SUBJECT: Portion of Eubank Village (1-21)  
Shopping Center (Indian School & Eubank Blvd.)

REF: GRADING AND DRAINAGE PLAN FOR A PORTION OF EUBANK VILLAGE SHOPPING  
CENTER (J21-D18) RECEIVED JANUARY 20, 1984

REF: REVISED DRAINAGE PLAN FOR PORTION OF EUBANK VILLAGE SHOPPING  
CENTER (J21-D18) RECEIVED FEBRUARY 10, 1984

DRAINAGE PLAN

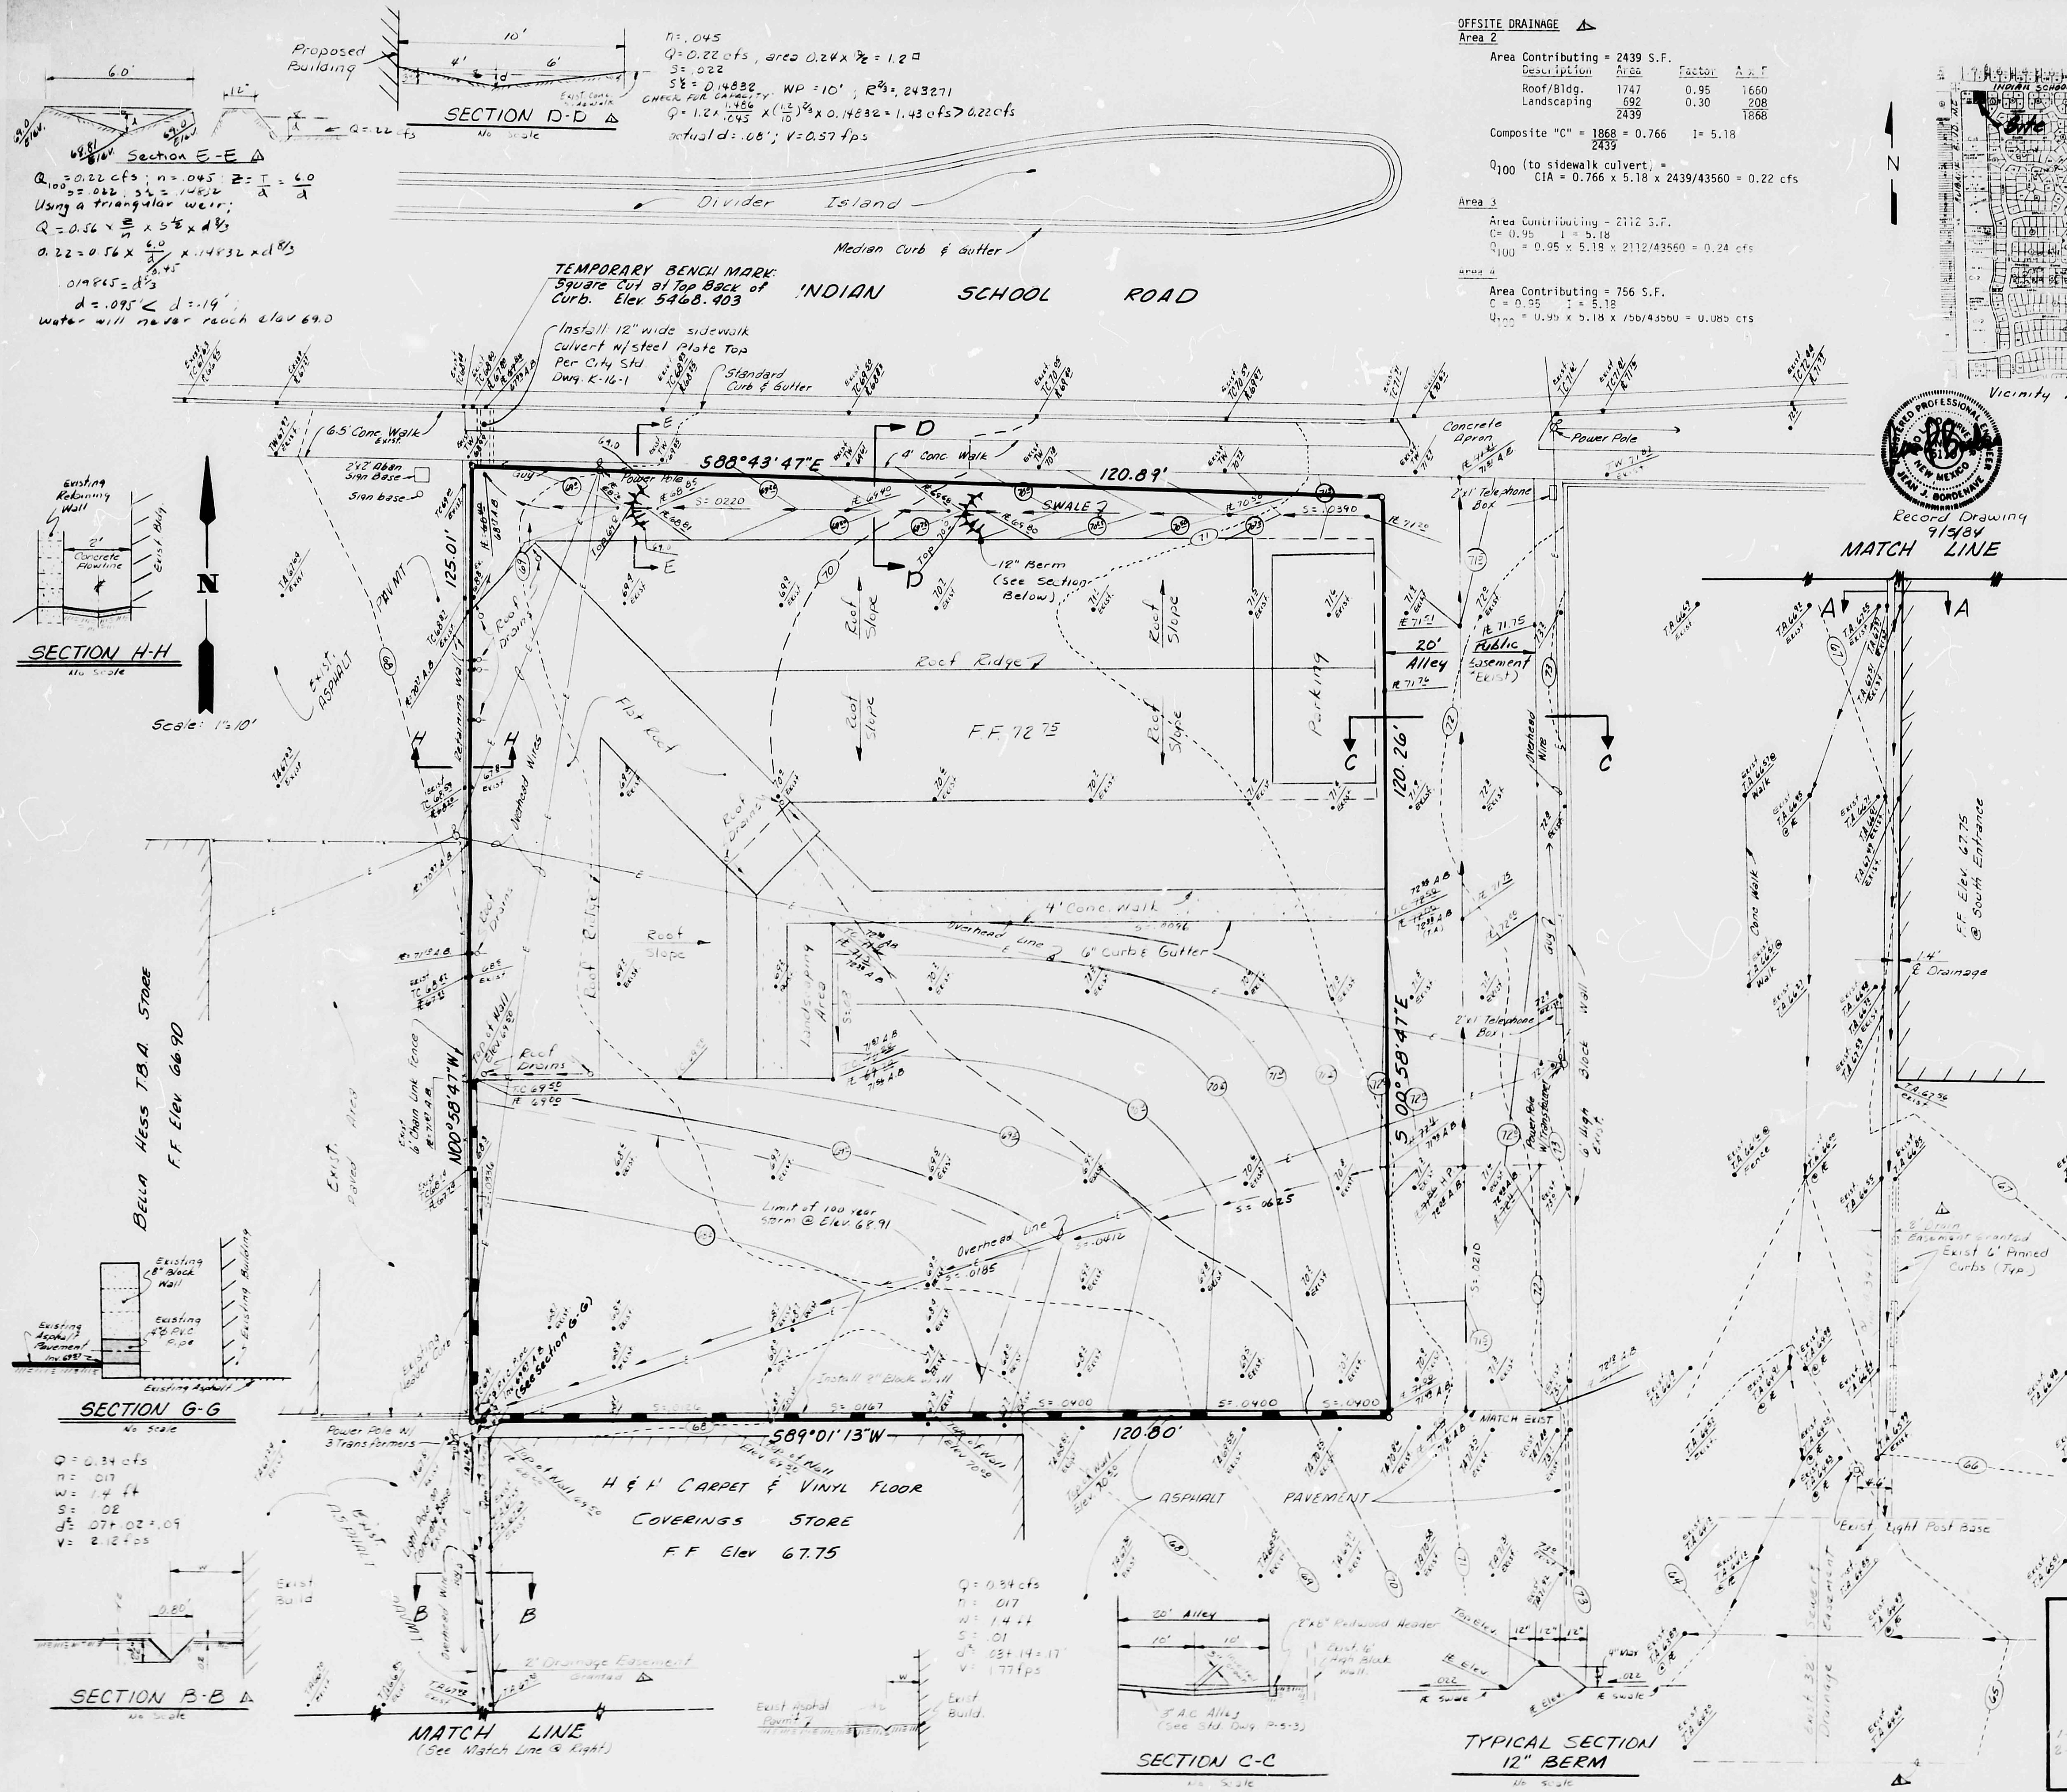
1. The plan has not been signed.
2. Discussion as to flood hazard has not been addressed.
3. An Erosion Control Plan will have to be provided in the plans  
for the period of construction.

4. The hydrology and hydraulics have not been addressed for the  
sidewalk culvert at the northwest corner of the site.
5. How does the swale to the north work? Do the berms pond water?  
If so, at what depth and is there a chance it will spill over into  
Indian School R/W?

6. Where does the flow go when it goes through the two (2) foot  
drainage easement? What is the outfall?
7. The watersurface through this easement will be at a depth up on  
the wall of the carpet business building as proposed. Either  
the grade will need re-adjusting or the wall will need to be  
waterproofed to prevent damage to that structure.

8. The plan indicates some top of wall elevations along the south  
boundary. Is this wall existing or is it to be constructed?
9. Are the elevations for the alley associated with City approved  
alley grades? Has any of this alley been vacated such that the  
grades are not of concern?

10. Please provide this department with a copy of the recorded easement and show its limits on the plan.
11. It is indicated on the plan that a detail of the four (4) inch outlet pipe is shown; however, I cannot find that detail.

- 1) The Plan has been signed.
- 2) The proposed improvement is not in the flood zone area.
- 3) An Erosion Control Plan has been provided.
- 4) A runoff of 0.22 cfs would outlet to Indian School Road. The 12" sidewalk culvert is sufficient to carry this Q.

- 5) The swale carries runoff to the sidewalk culvert. The berm ponds the water. The water will never spill to Indian School Road. (See section E-E and computations.)

- 6) The flow of 0.34 cfs goes into a existing 32' drainage easement, goes west-erly and into an existing inlet on Eubank Ave.
- 7) The existing elevations along the 2' easement shows that the existing pave-ment is banked to the west. Water will go along the side of the curb.

- 8) This is a proposed wall for this project. It has been indicated on plan.
- 9) The alley southeast of our improvement is presently paved. The existing contours on the alley east of our proposed project is sloping southwesterly and runoff presently drains to adjacent properties. By improving this alley on our side, we feel that it does not warrant City approved grades. A runoff of 0.24 cfs only is being diverted to Indian School Road.

- 10) A copy of the 2' drainage easement granted is attached.

11) It has been incorporated.
